Development Facilitation Team (DFT) – Review Comments

DRB Project No: PR-2020-003484 Date: 06/28/2023 Agenda Item: #9 Zone Atlas Page: E-10

Legal Description: Lots 2 & 3 Block 12 unit 3, Volcano Cliffs SUBD

Application For: SD-2023-00048 – PRELIMINARY PLAT (DHO)

PRELIMINARY PLAT FOR  
**MOJAVE RIDGE SUBDIVISION**  
 (A REPLAT OF LOTS 2 & 3, BLOCK 12,  
 UNIT 3, VOLCANO CLIFFS SUBDIVISION)  
 WITHIN  
 SECTION 27,  
 TOWNSHIP 11 NORTH, RANGE 2 EAST, N.M.P.M.  
 CITY OF ALBUQUERQUE  
 BERNALILLO COUNTY, NEW MEXICO  
 JANUARY, 2023

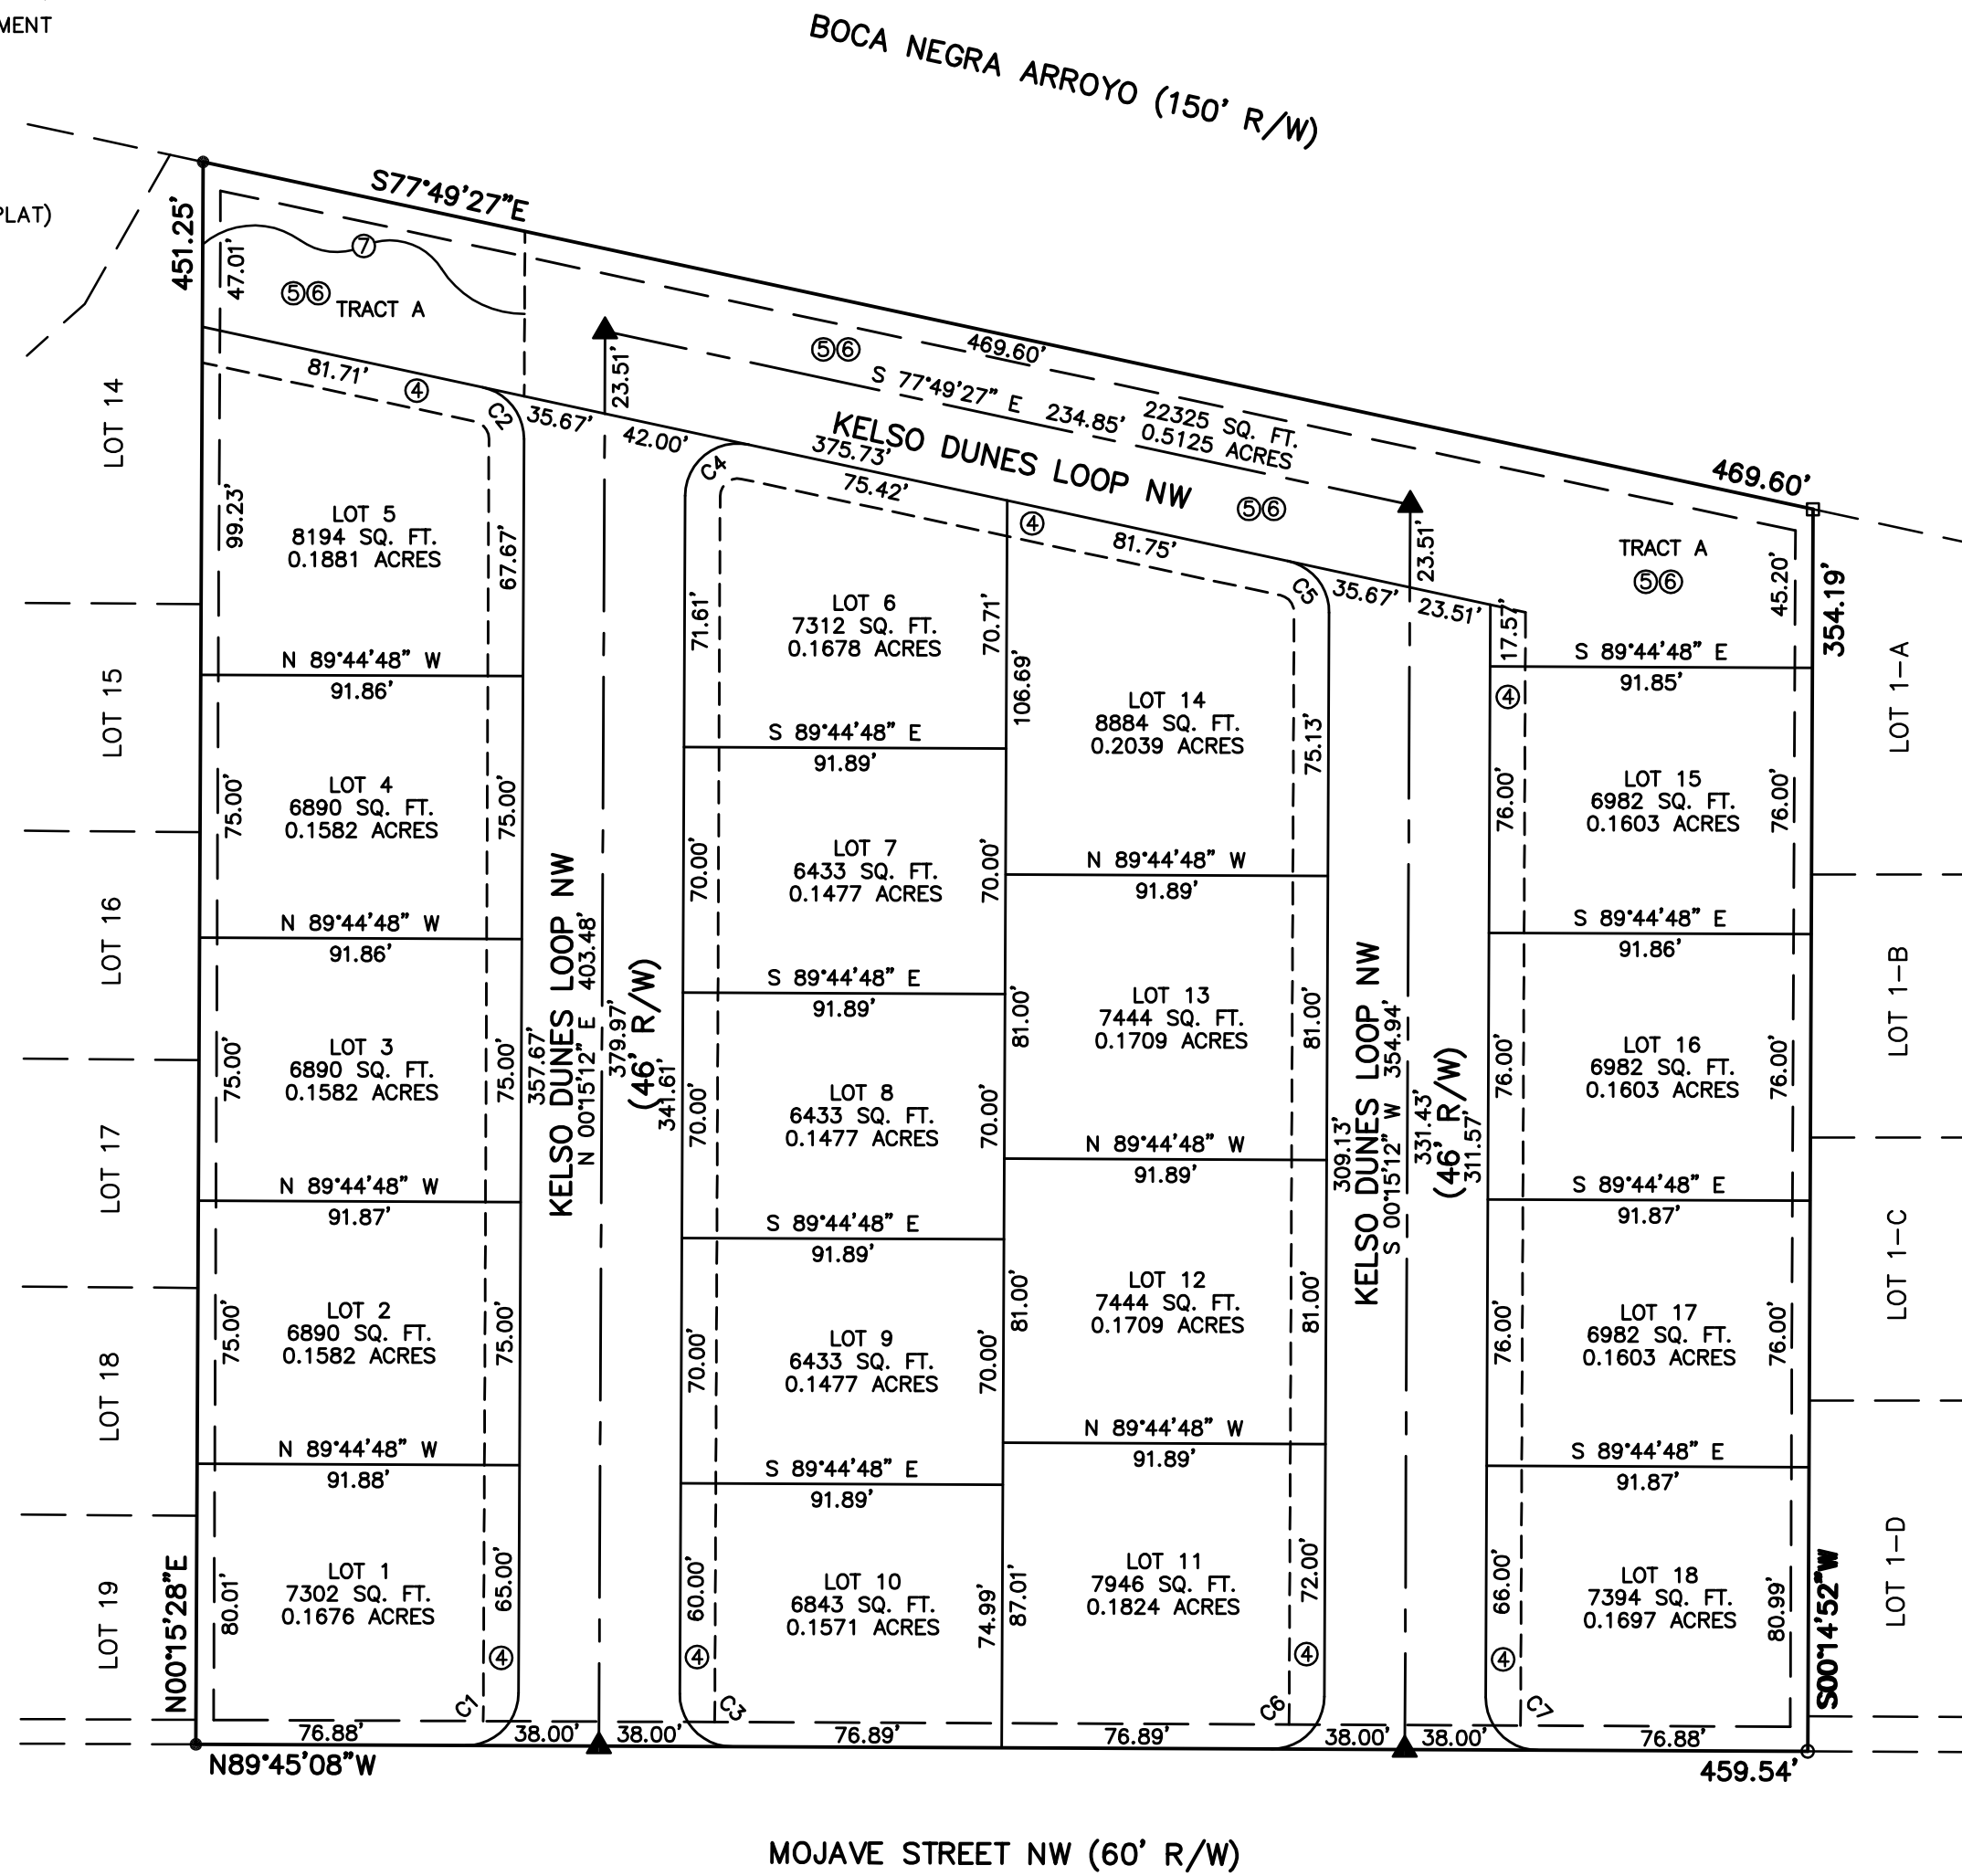
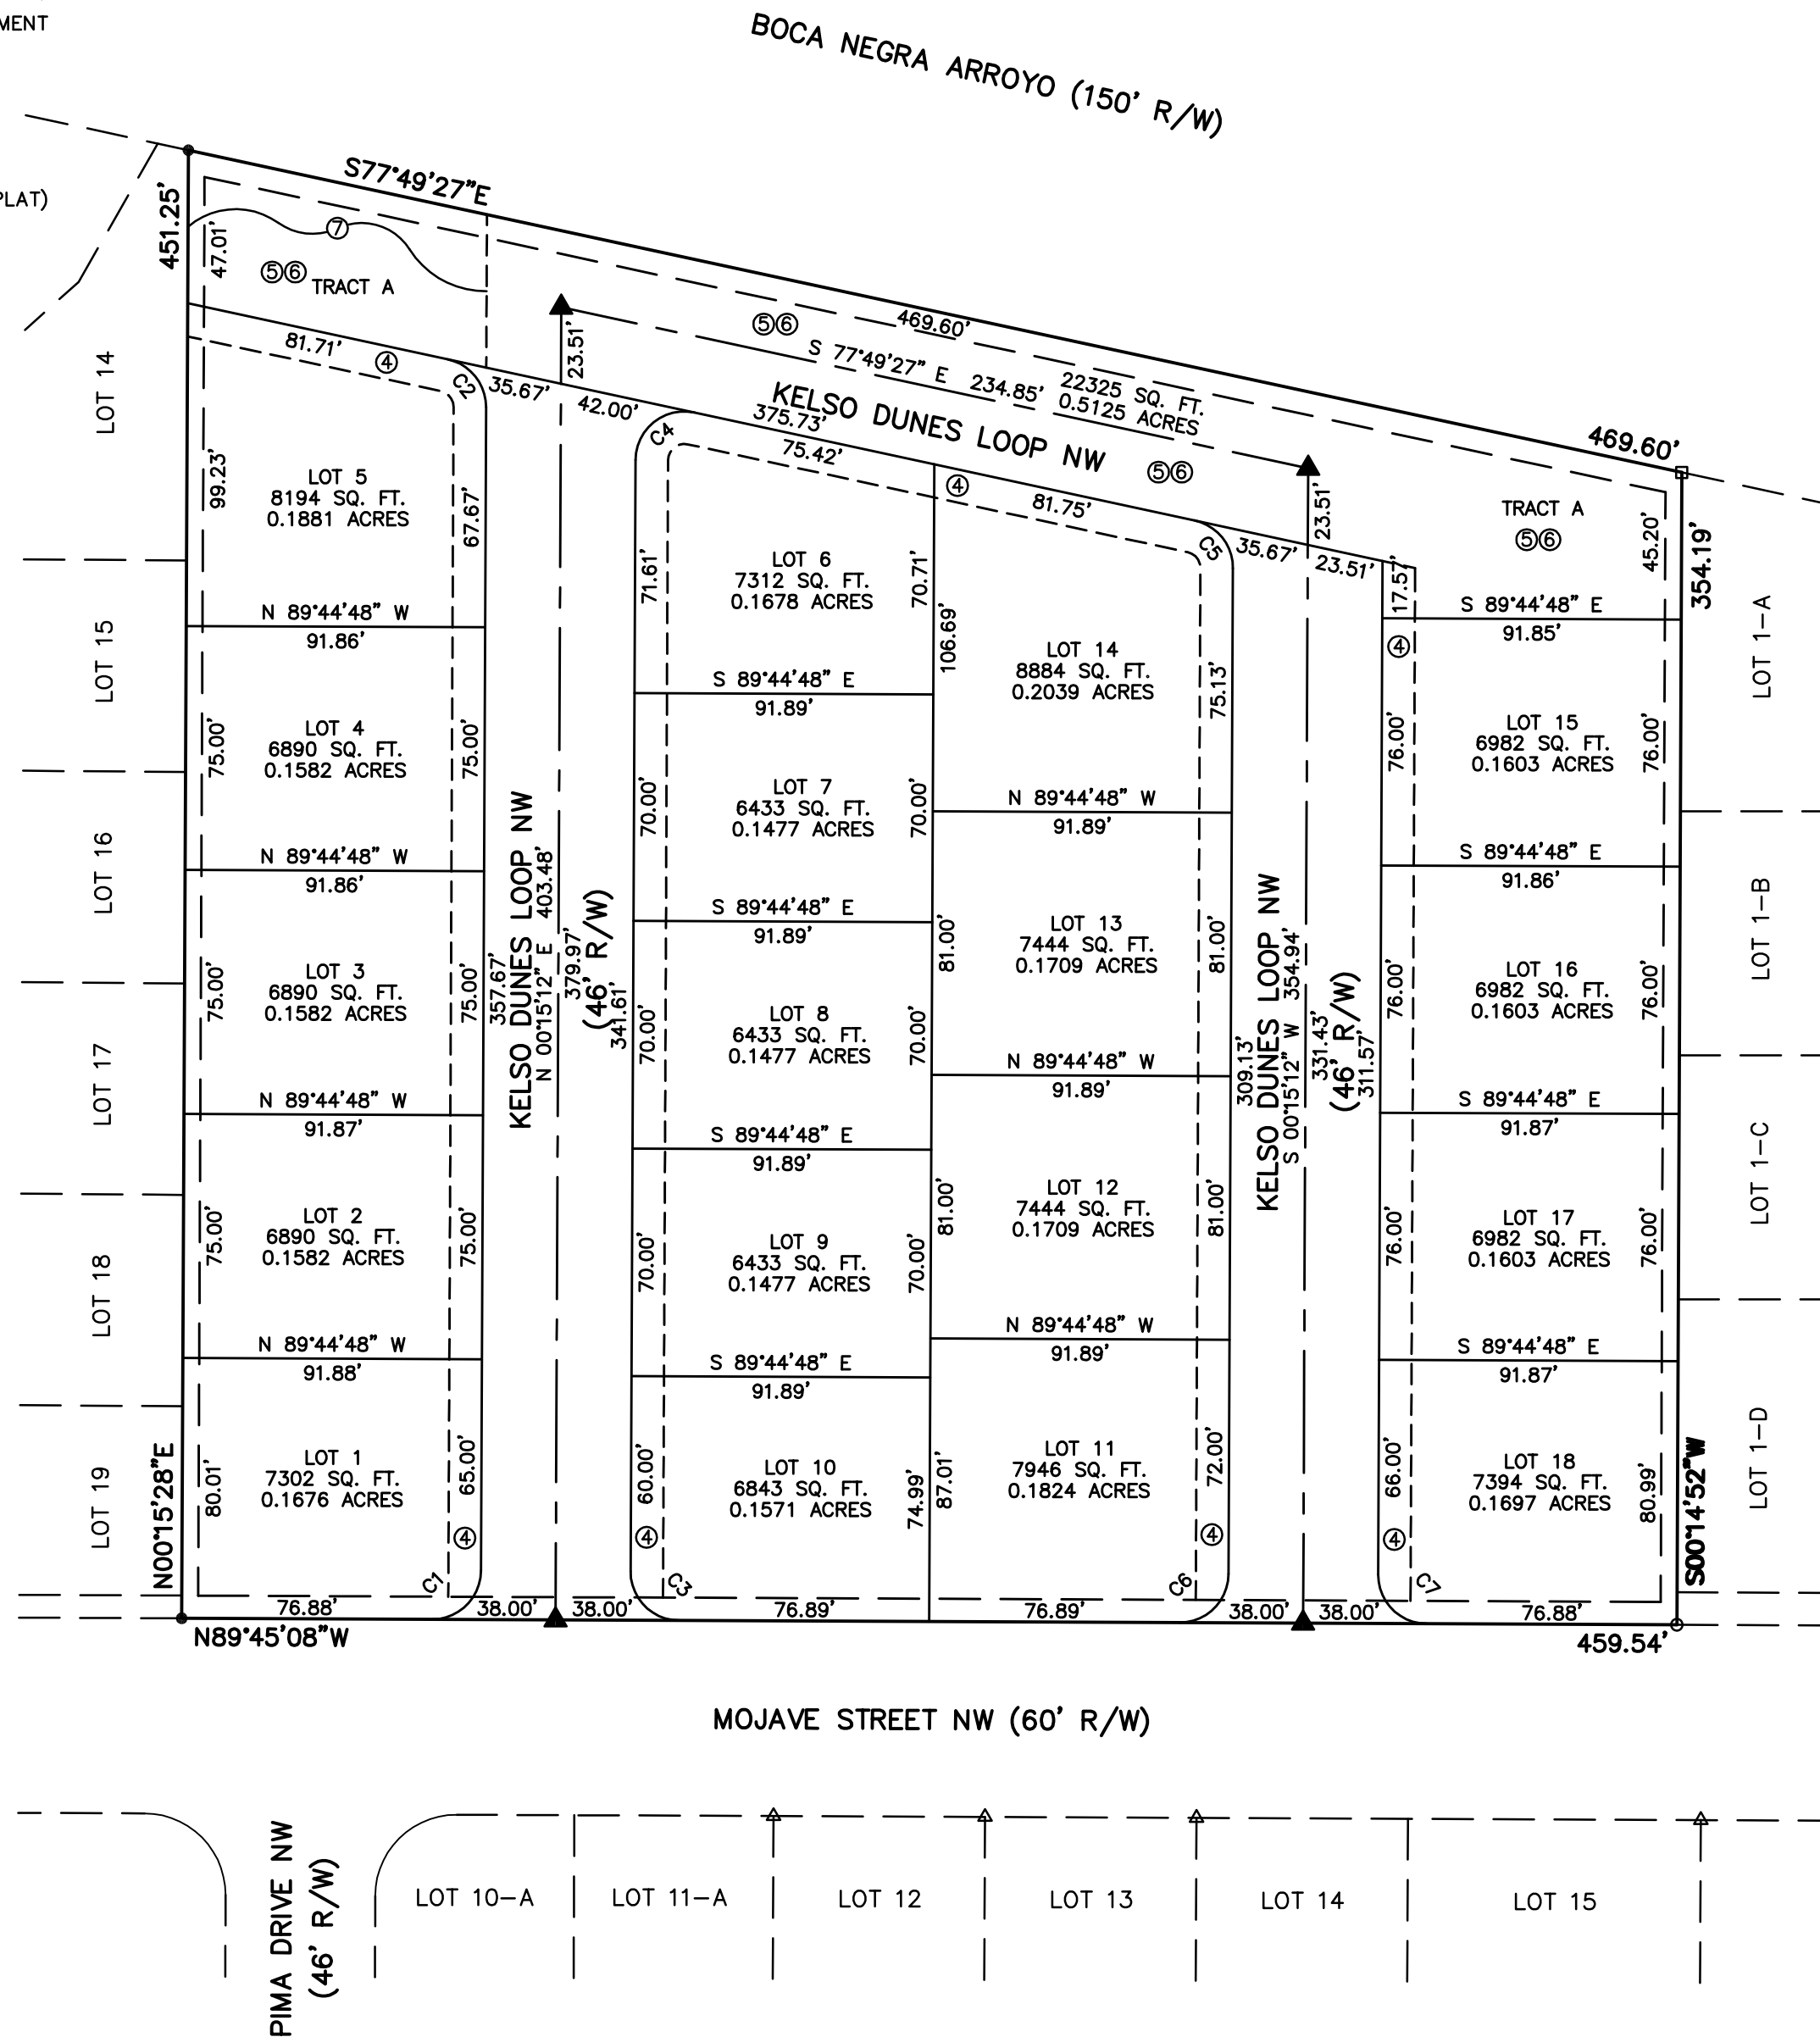
1. Since the IDO indicates the 45 foot required buffer required as per IDO 5-2(J)(2)(a)(1) must be approved by the Open Space Superintendent, Code Enforcement would like to confirm Parks is in agreement with the plat proposed showing Tract A will serve as that buffer. The required landscape buffer area should be clearly marked and noted on the plat, as discussed in prior Hearings (on 5/10 and 6/28).
2. CE has no further comments or objections.

- **Updated 10.11.23** 5-2 (J)(2)(a) Lot 5 is abutting the Boca Negra arroyo. Add a note to the plat indicating that the 45 feet buffer abutting the Petroglyph National Monument must have plant approval and location per the Open Space Superintendent.

Due to the adjacency of the subject site to MPOS, there is a 45' Open Space Buffer at the eastern and western portions of the site that are required to be on the plat. Please indicate on the plat that the parcel to the north is Major Public Open Space, zoned NR-PO-B. Landscaping will need to be approved by the Open Space Superintendent.
